From: Marge Schmuckal
To: Kandi Talbot
Date: Tue, May 4, 2004 3:33 PM
Subject: 19 Rice Street - I-M zone

354-A-003

I have reviewed the latest submittal for the new parking at 19 Rice Street. Their submittal changes some of the sizes of areas. The new uses breakdown is now:

SD-1

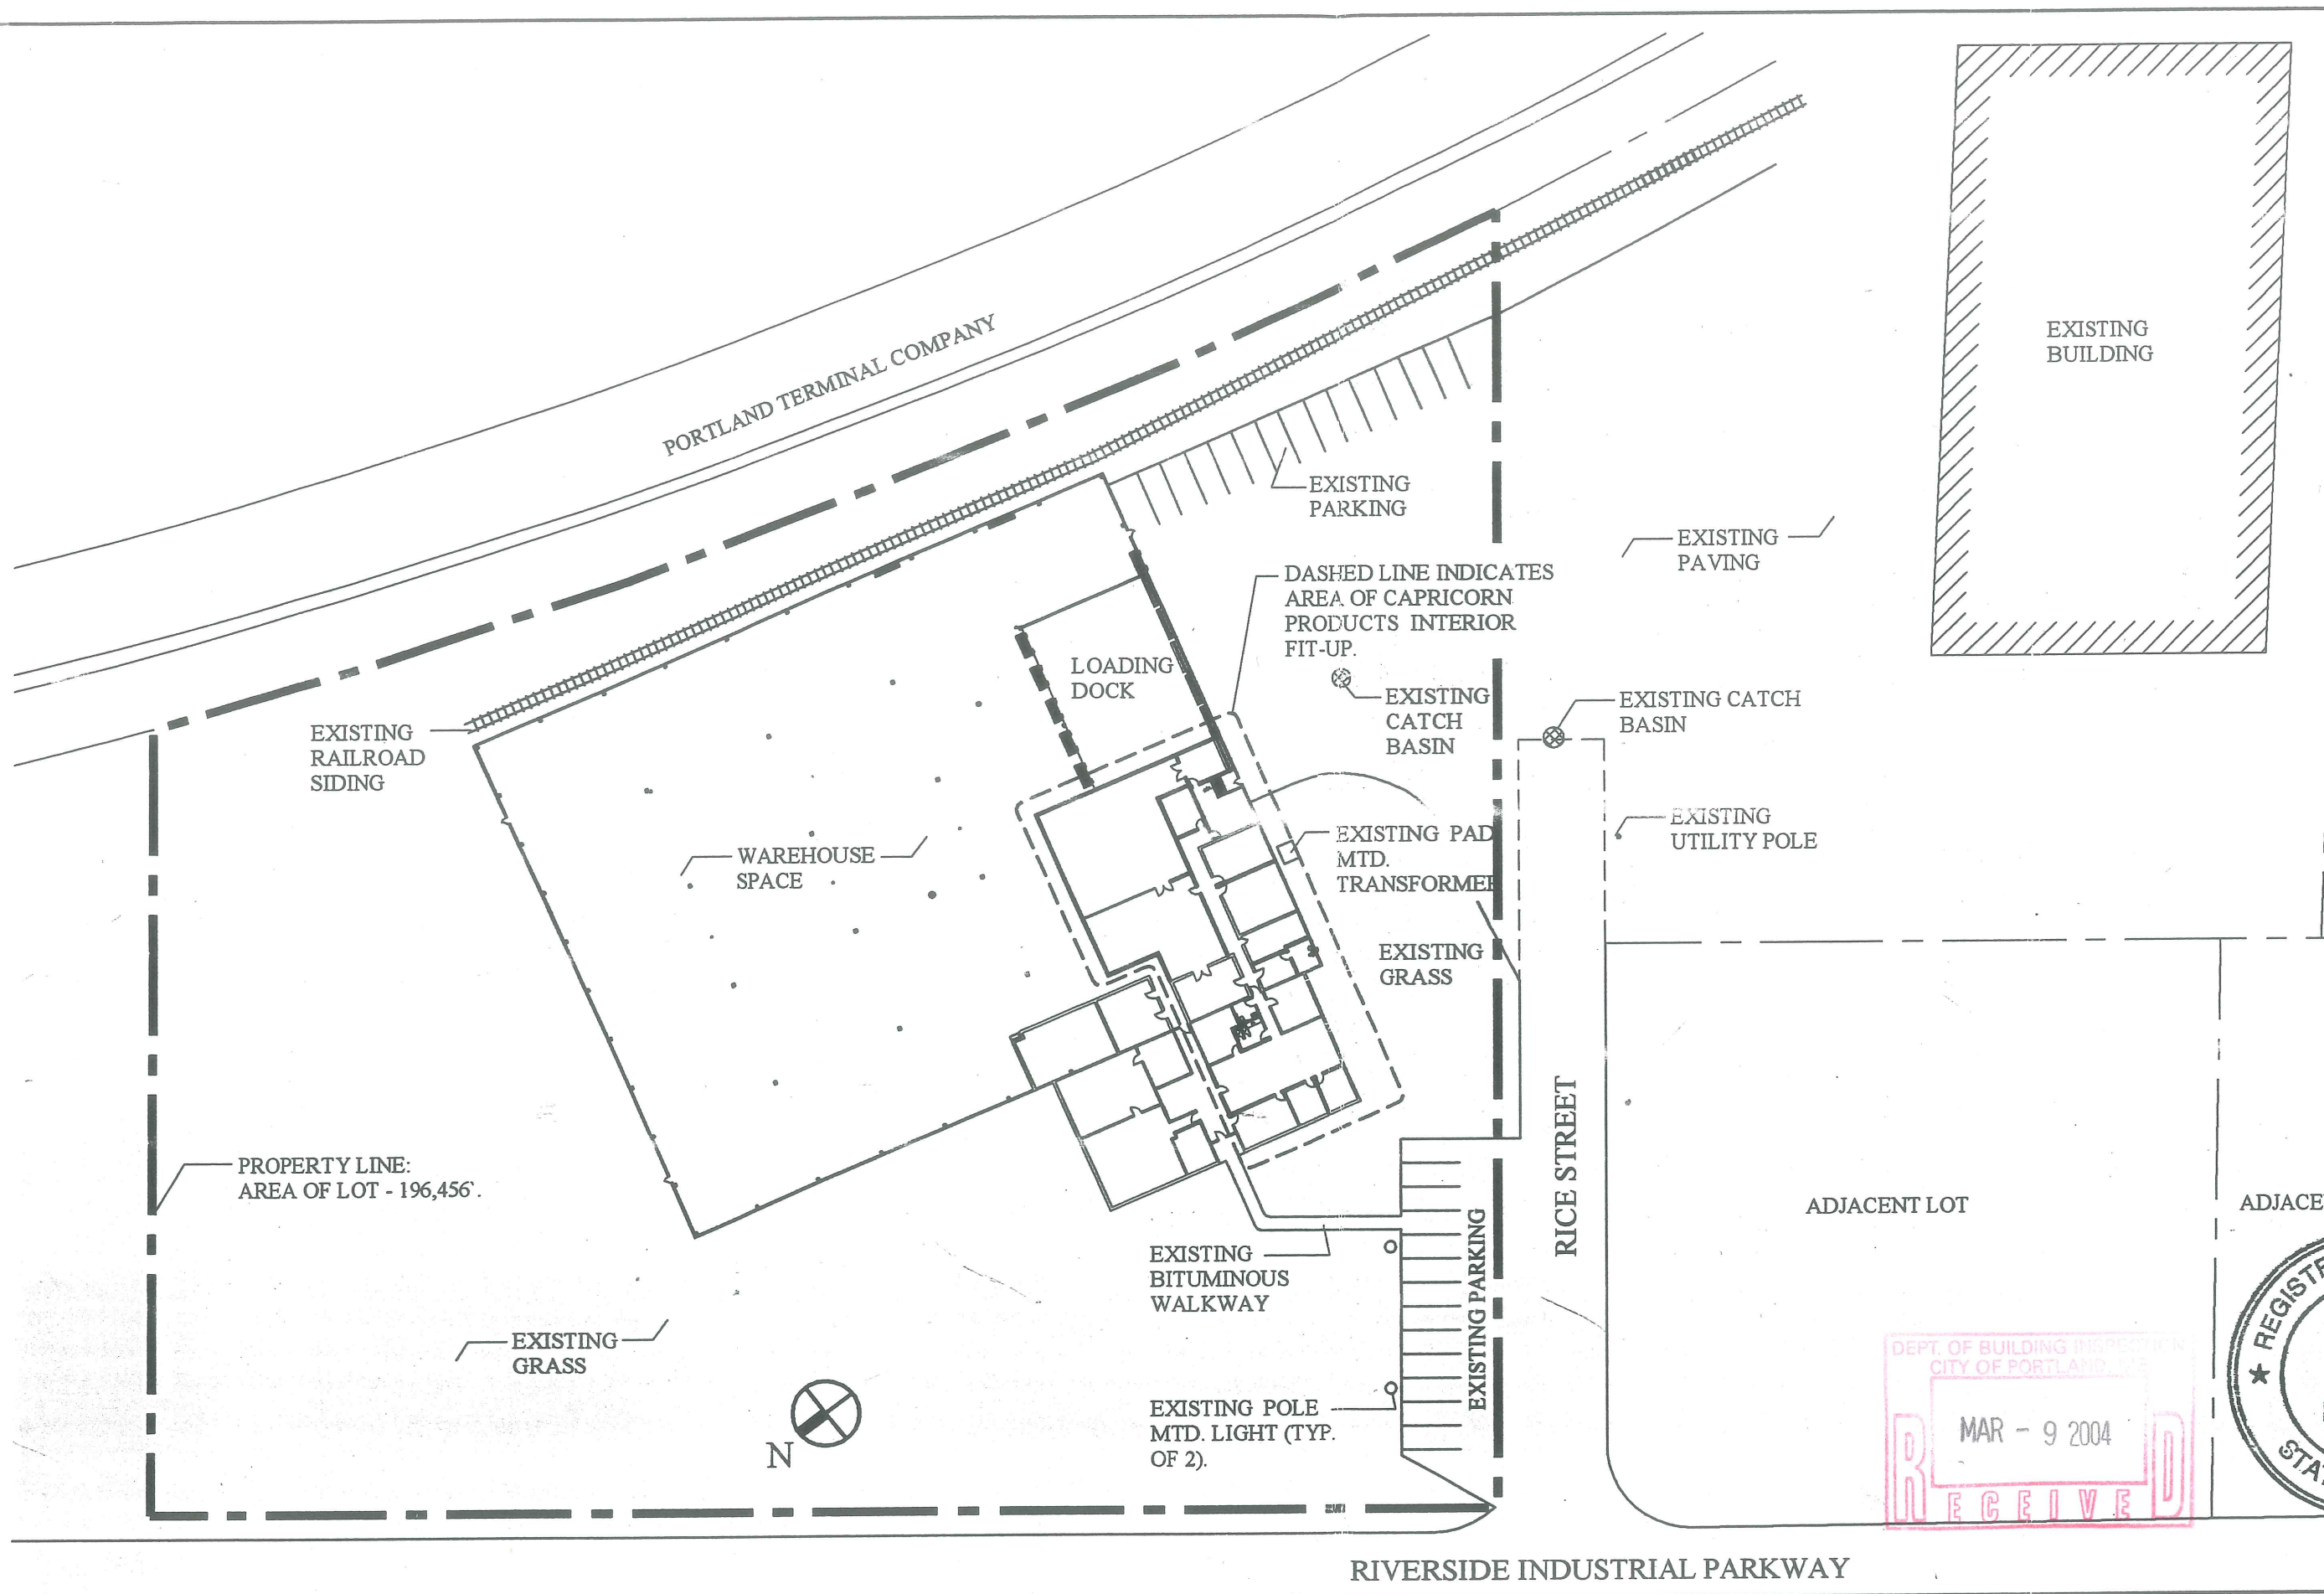
A total of 63 spaces are required - I have counted 71 spaces as being provided at this time. So they are in compliance.

The I-M zone requires no more than 75% impervious surface. My figures show that they are under the 75% requirements.

The I-M zone also requires a 10 foot setback for pavement from property lines. 20 foot and over is shown. The plan is meeting this requirement.

The submitted plans comply with the I-M zone requirements.
